Consultation Response from Chris Bembridge KC, Highways Development Management
2023/91715 Mohaddis E Azam Education Centre And Masjid E Madani, 225C, Ravenshouse Road, Dewsbury Moor, Dewsbury, WF13 3QU
Demolition of existing mosque and erection of mosque and education centre
Date Responded: 25/01/24 Responding Officer: CNB Responding Ref: K14-5SE/4

This application is for revised information in the form of a Transport Statement from TPS Transport Consultants dated December 2023 (issue 1) and a Construction Traffic Management Plan also from TPS Transport Consultants dated December 2023 (issue 1).

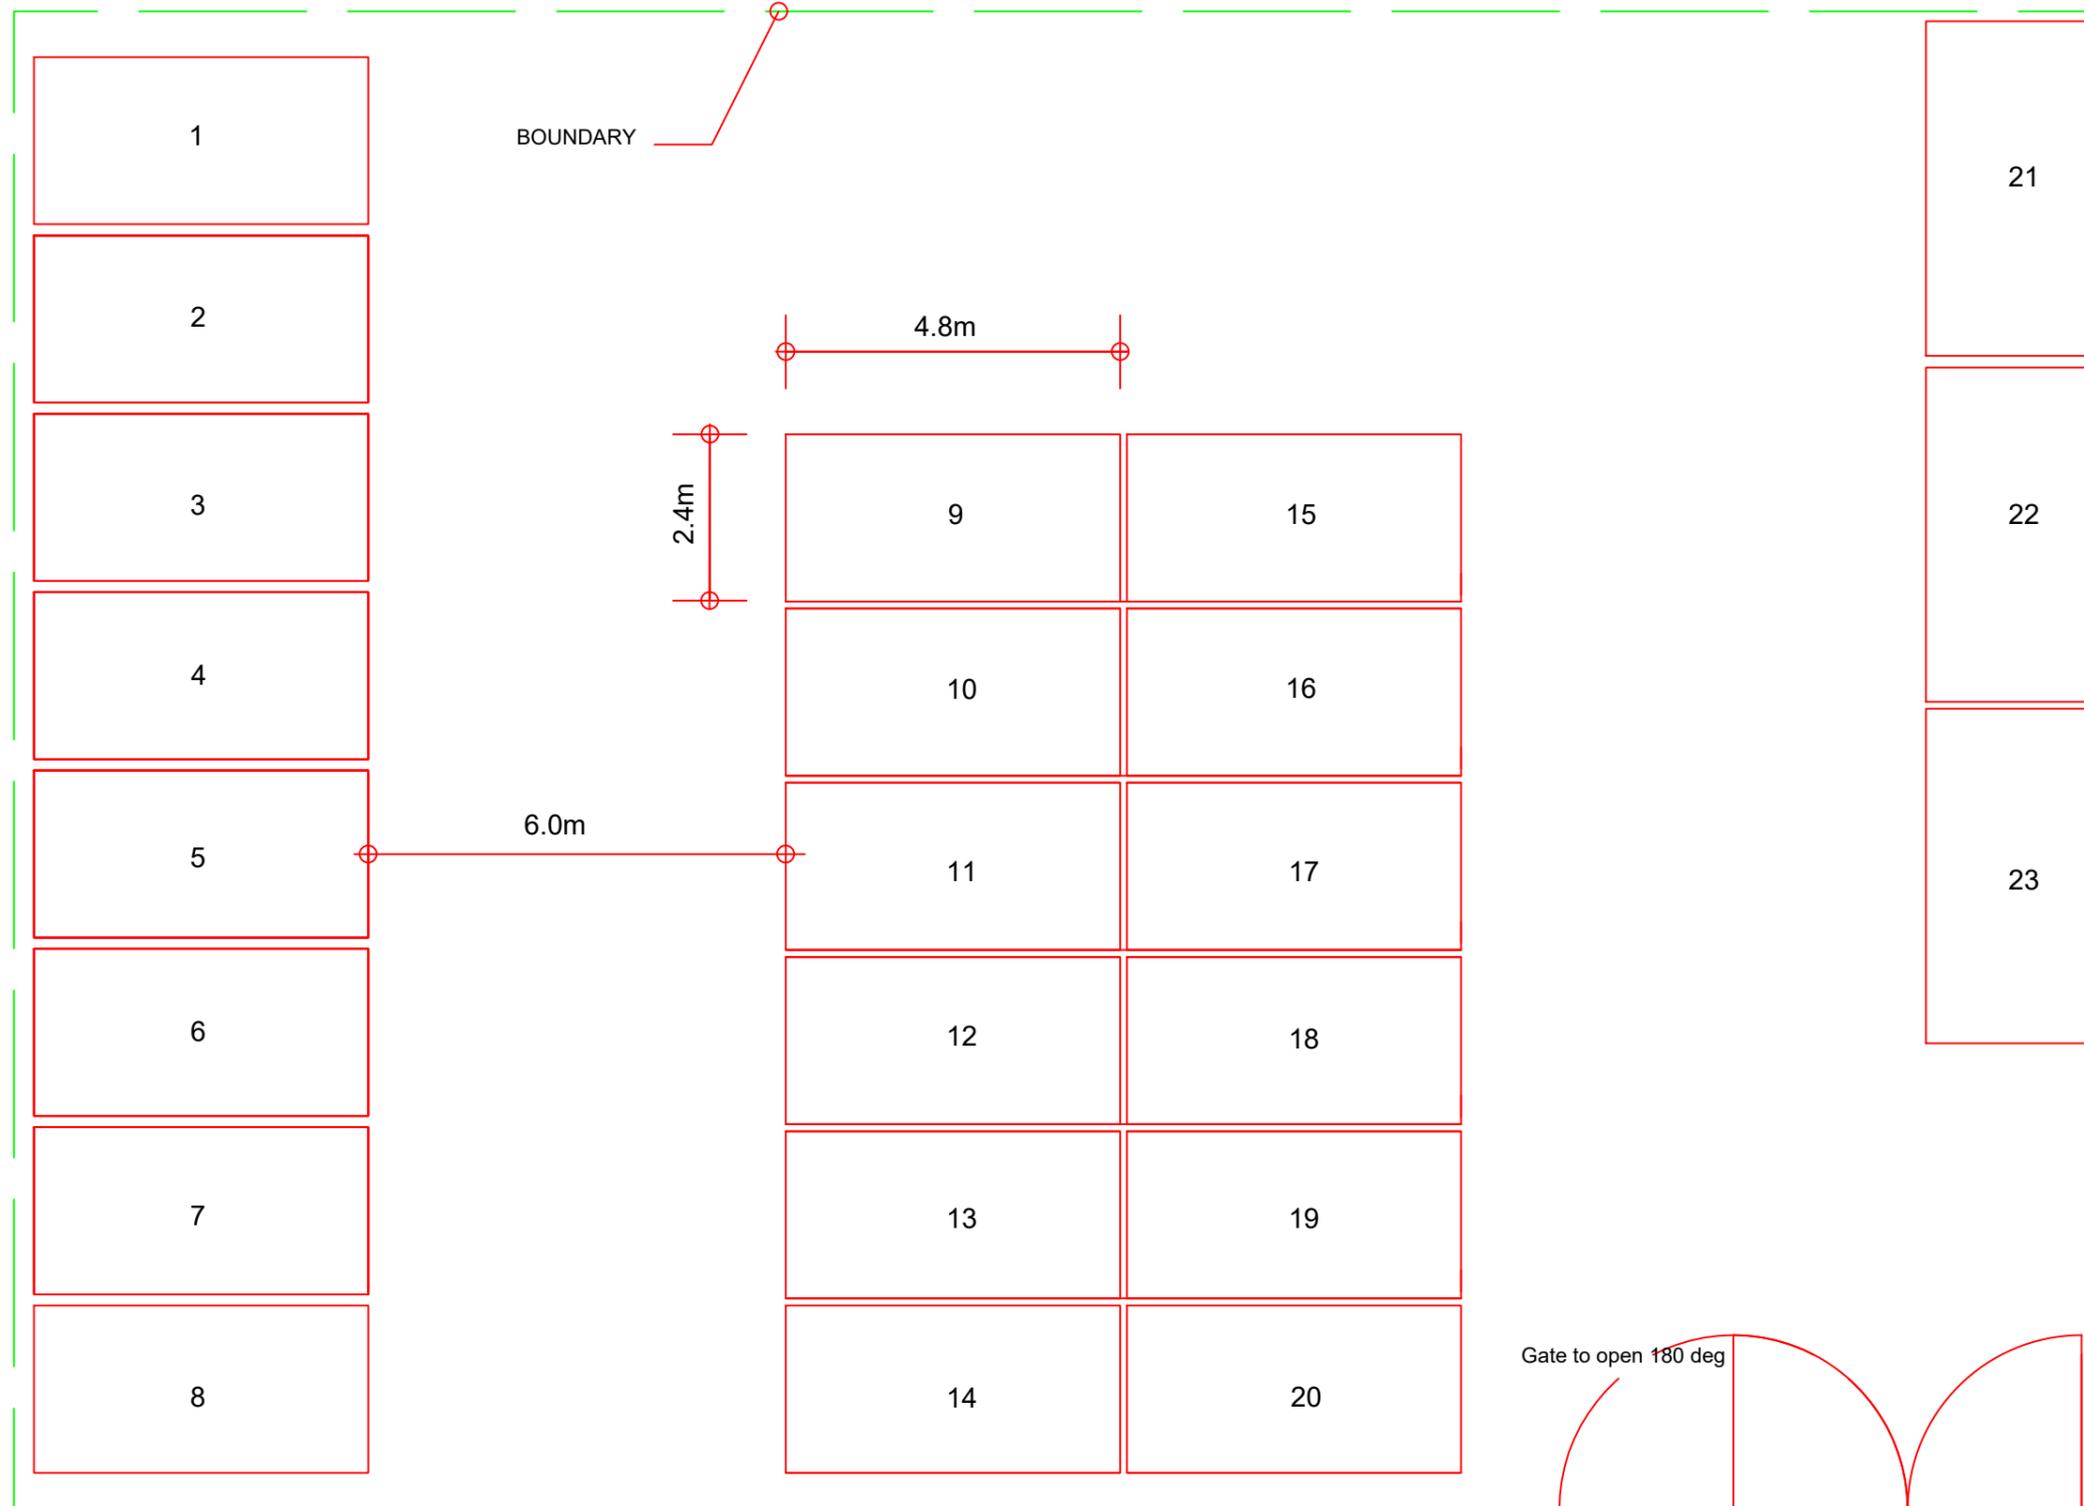
The initial assessment for the permitted site (19/92515) was for an internal area of approximately 632sqm as given on the application form, the current proposals are for approximately 975sqm as indicated on drawing No AIB 01, an increase of approximately 343sqm, although it is appreciated that not all this internal space will be occupied by users and includes staircases and access landings/corridors.

The proposed car park is set out in drawing No AIB/01 Proposed Layout (Sept 2021) and shows a single access with 23 parking spaces, however paragraph 4.6 of the submitted planning statement suggests that there are spaces for 26 cars with two disabled spaces and this is not what is shown on the parking layout drawing. The parking spaces scale to approximately 2.4m x 4.8m with a 6m headway between spaces 1 to 20 to allow cars to manoeuvre safely. Spaces 21 to 23 are tandem against the edge of the car park and don't allow for independent access, ie space 23 would block in the other two spaces and space 22 would block in space 21. This may be suitable for staff parking or use at prayer times if

Drawing No AIB/01 Proposed Layout (Sept 2021) shows the car park with a single access over a dropped kerb crossing. The site, as constructed, has two gates and two dropped kerb crossings on to Ravenshouse Road and a single vehicle and separate pedestrian access on to the Back Ravenshouse Road. To comply with the proposal drawing we would like to see the second gated access on Ravenshouse Road (to the south) removed and the redundant dropped kerb crossing reinstated to a full kerb with the “H-bar” marking removed, and the vehicular access on to Back Ravenshouse Road removing. These changes should be clearly marked on a drawing and should be conditioned for highway safety reasons if you are minded for approval, and the works done within a s184 legal agreement with the council, with an appropriate footnote included, wording can be provided if required.

DWG NO : AIB / 02 REV :

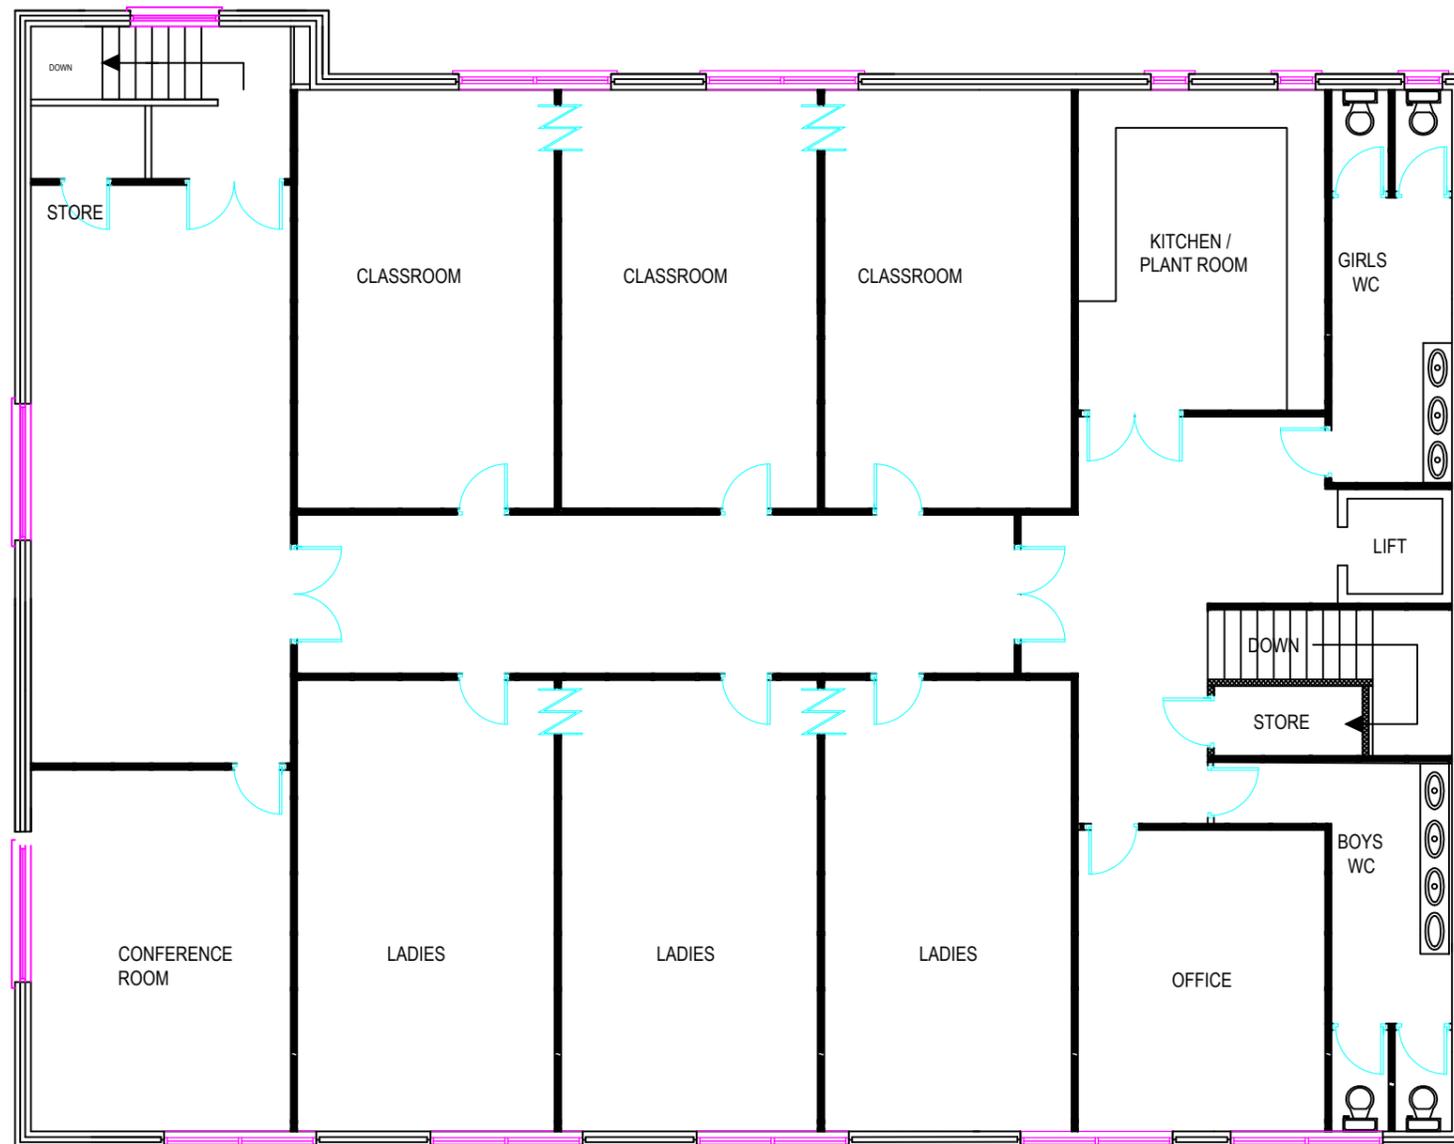
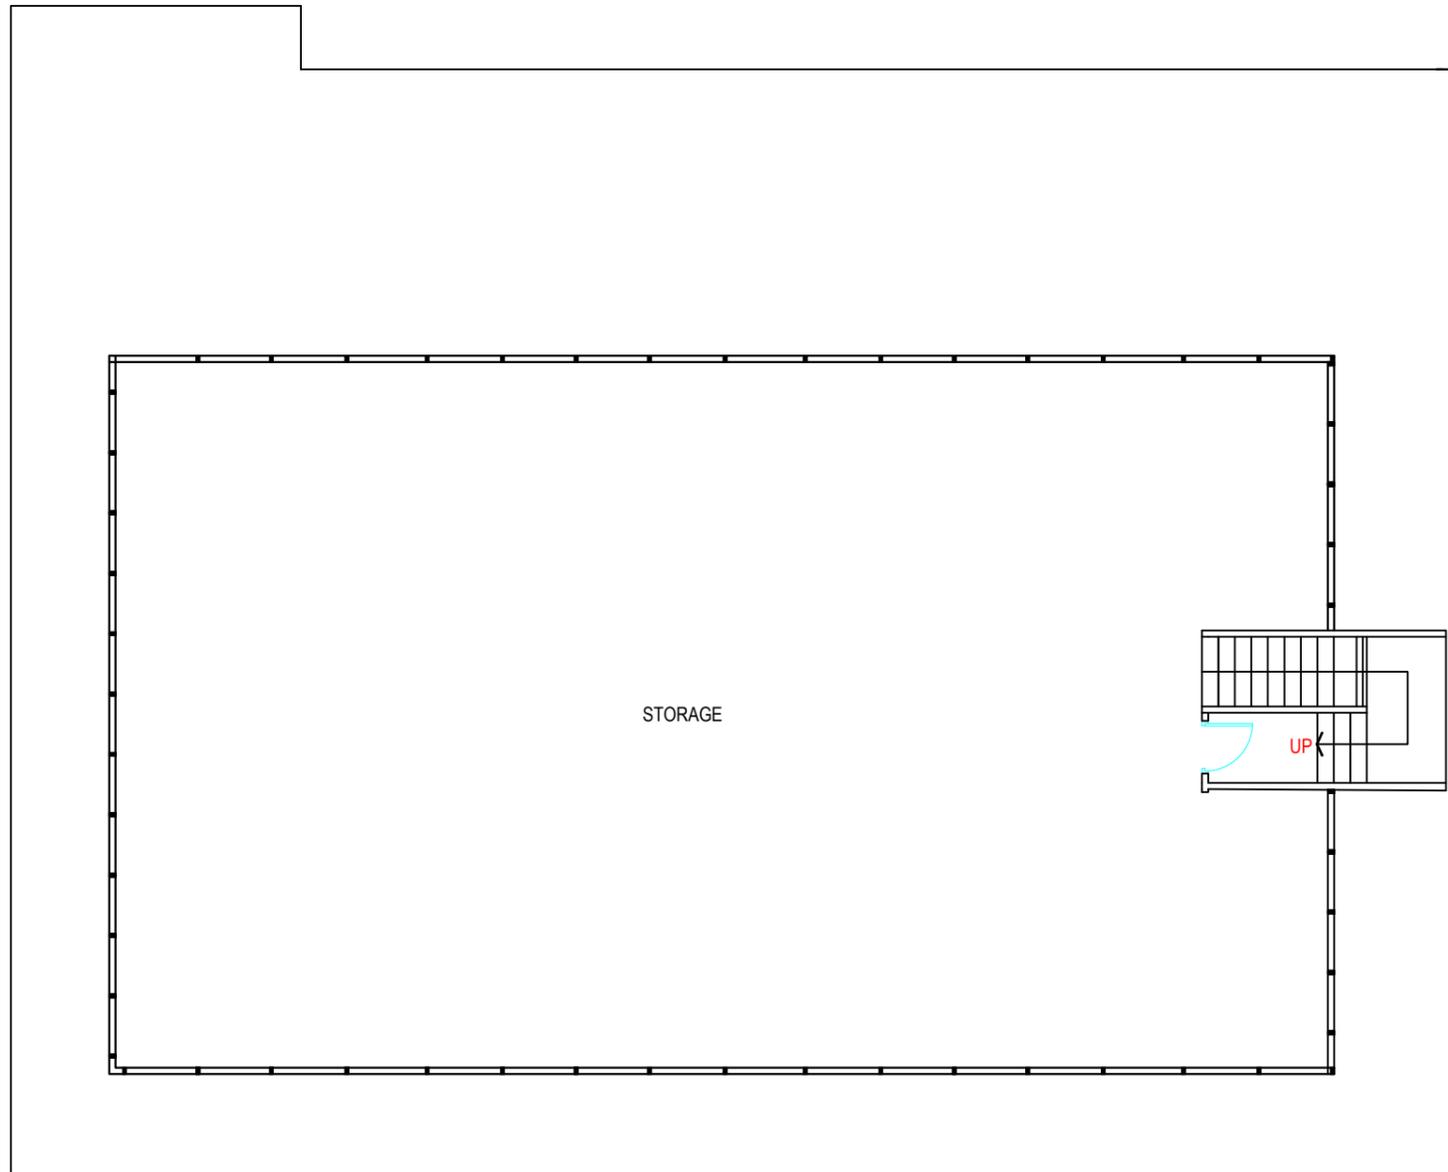
It is also noted that the within the transport statement, paragraph 2.3 Development Proposals suggests that the first floor will have 3 classrooms, 3 ladies' rooms, and office, a small kitchen, and toilets, however drawing No AIB/02 also shows a conference room and another room between the conference room and the rear stairs. No mention is made in the Transport Statement for these two rooms or their use.
